**SOUTH DERBYSHIRE DISTRICT COUNCIL’S
ANSWERS TO THE ExA’S THIRD WRITTEN QUESTIONS
FOR DEADLINE 8**

Oaklands Farm Solar Farm NSIP

PINS Reference: EN010122

Figure 1e: Habitat constraints plan

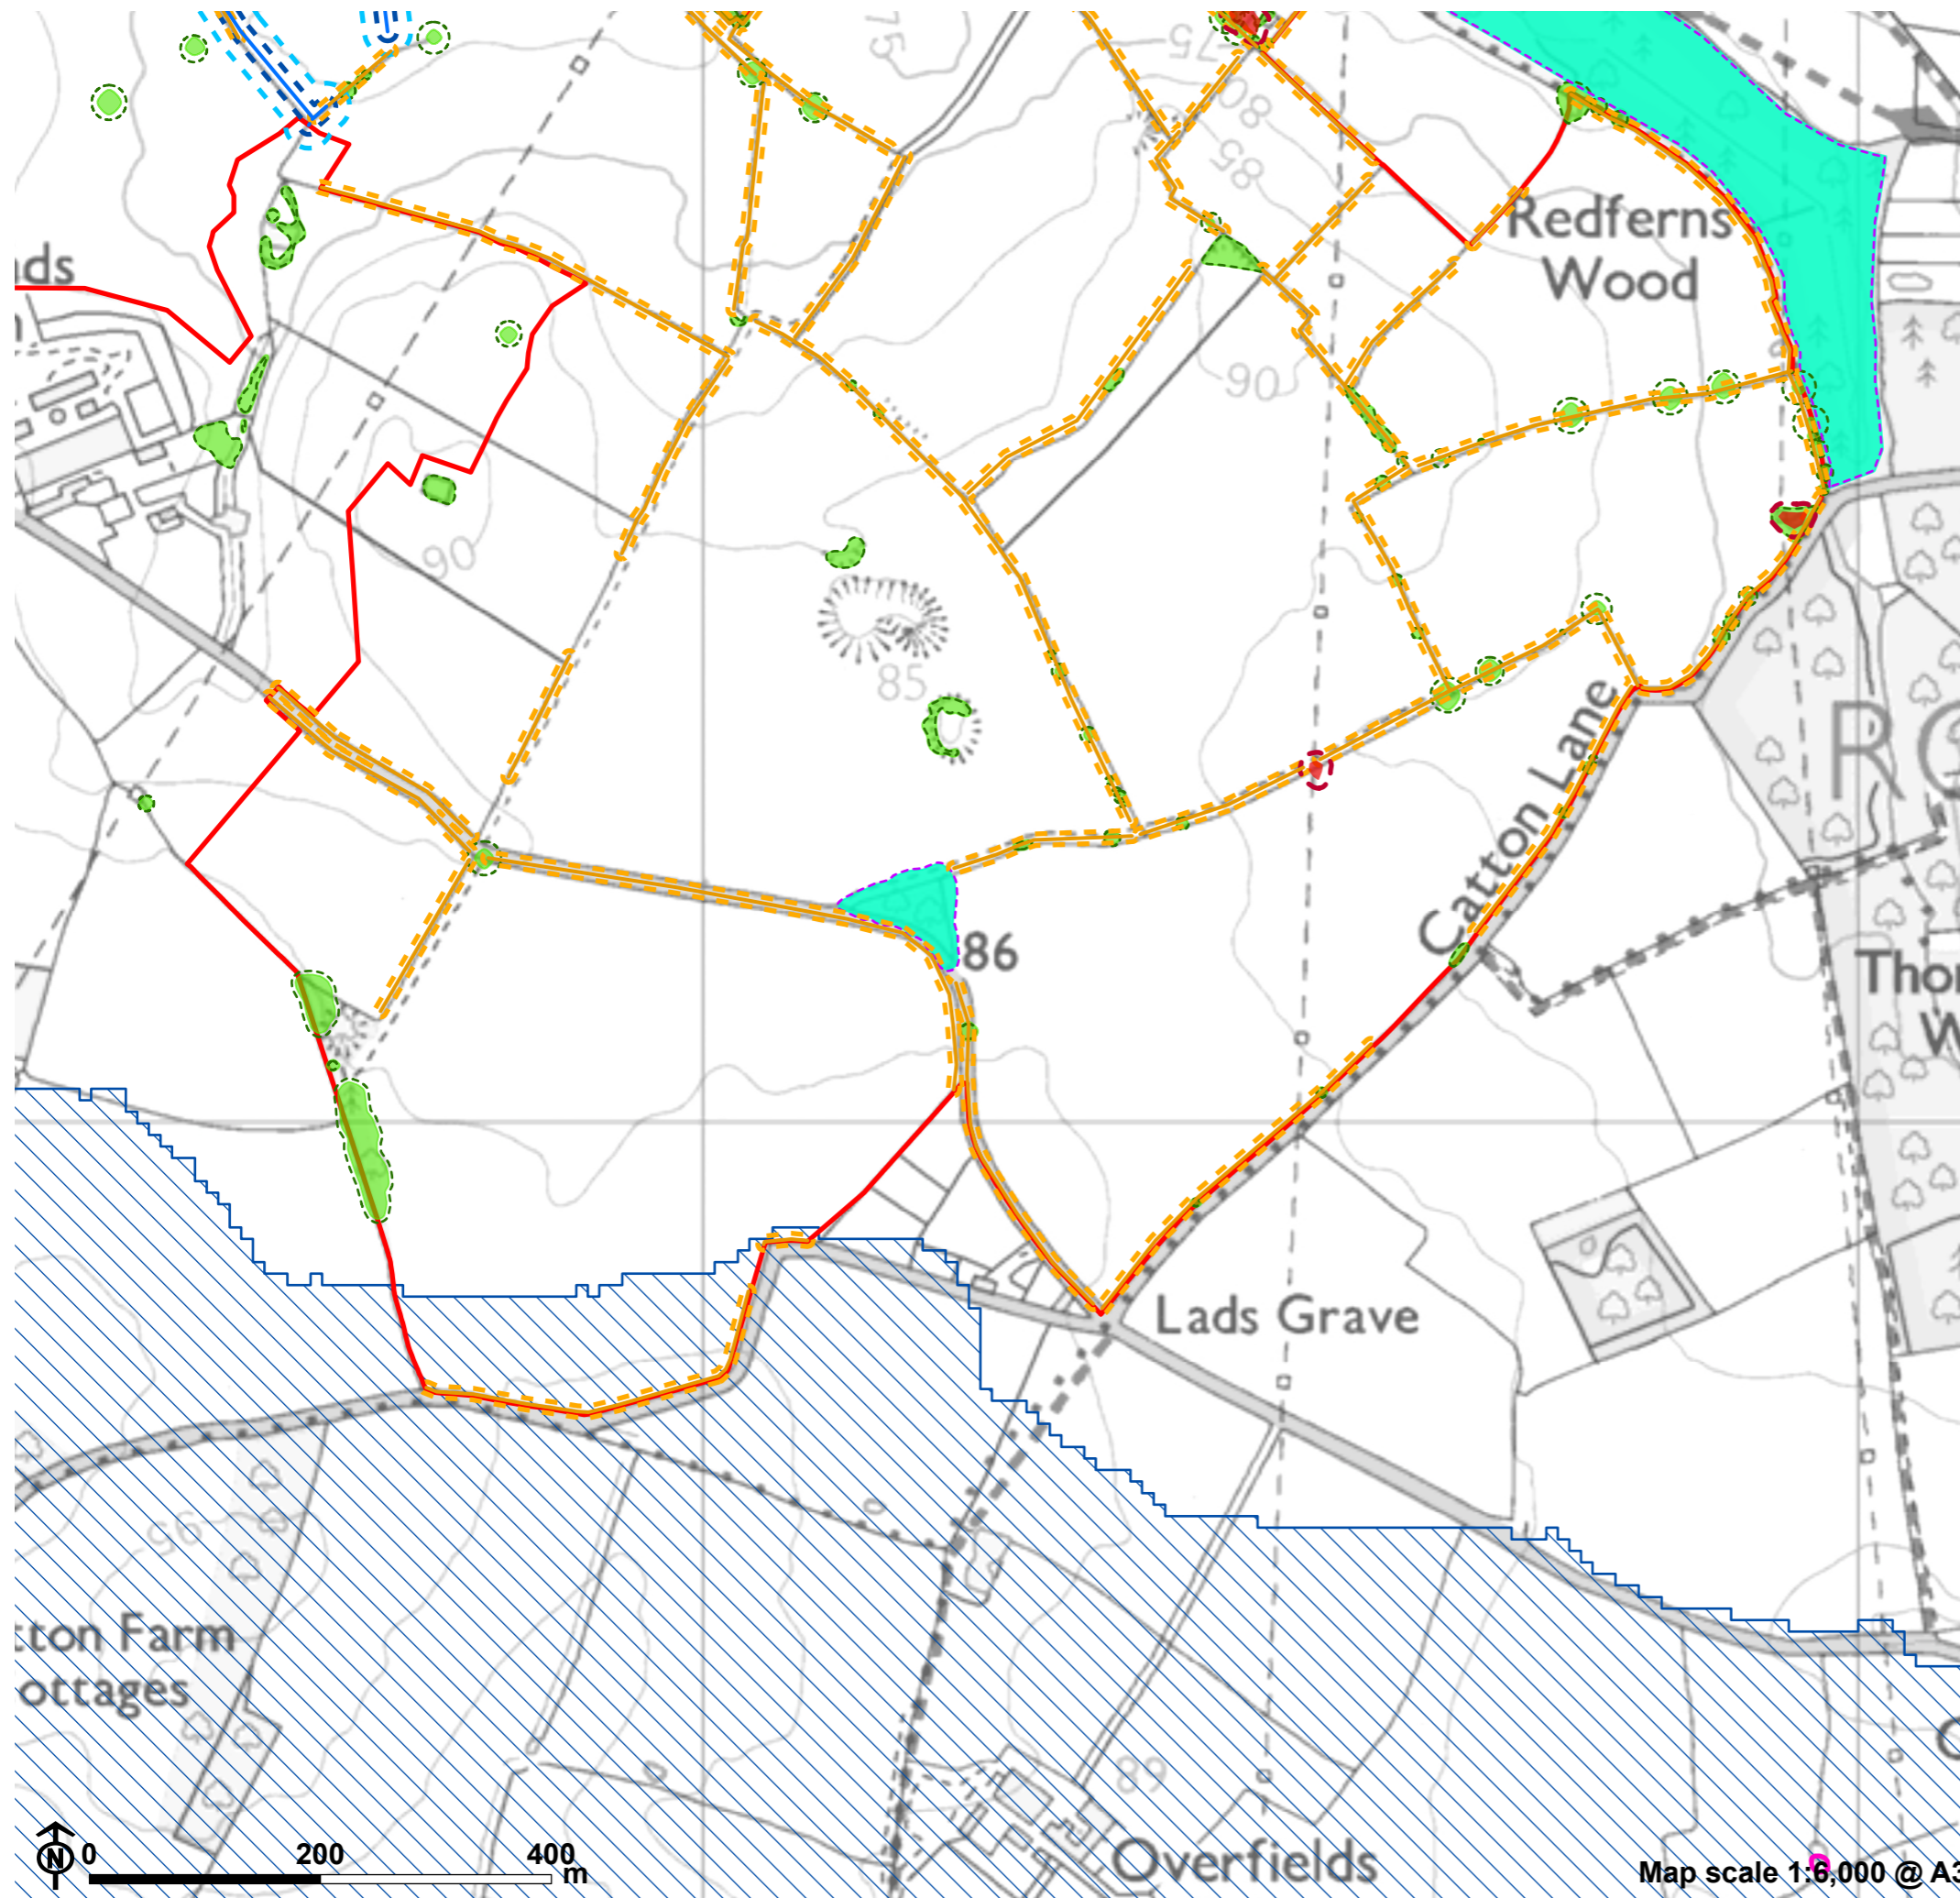
7.3	<p><u>Habitat Constraints Plan</u></p> <p>SDDC [REP4-014] and DCC [REP4-012] referred to the need for a Habitat Constraints Plan with interpretable maps to provide the necessary details and extent of site clearance works relating to buffer zones to sensitive features such as ancient/ veteran trees, other retained trees, ponds, watercourses, hedgerows and woodlands.</p> <p>The Outline CEMP [REP5-011] includes provisions for a Habitats Constraint Plan [Section 2.8.5] and buffers [Sections 2.6.4, 2.6.5, 2.8.2, 2.8.3, 2.8.5, and 2.8.6]. The Applicant provides a series of interpretable maps of habitat constraints [REP5-030].</p> <p>a) Please could the Applicant add the draft interpretable maps to the Outline CEMP [REP5-011] and secure that interpretable maps be included in the final CEMP?</p> <p>b) Please could SDDC and DCC comment?</p>	<p>c) SDDC has no further comments to add in addition to those previously made at Deadline 6, which are repeated below:</p> <p>“SDDC have reviewed those interpretable maps, and they provide useful clarity and should be attached to the Outline CEMP for further comprehensive review.”</p>
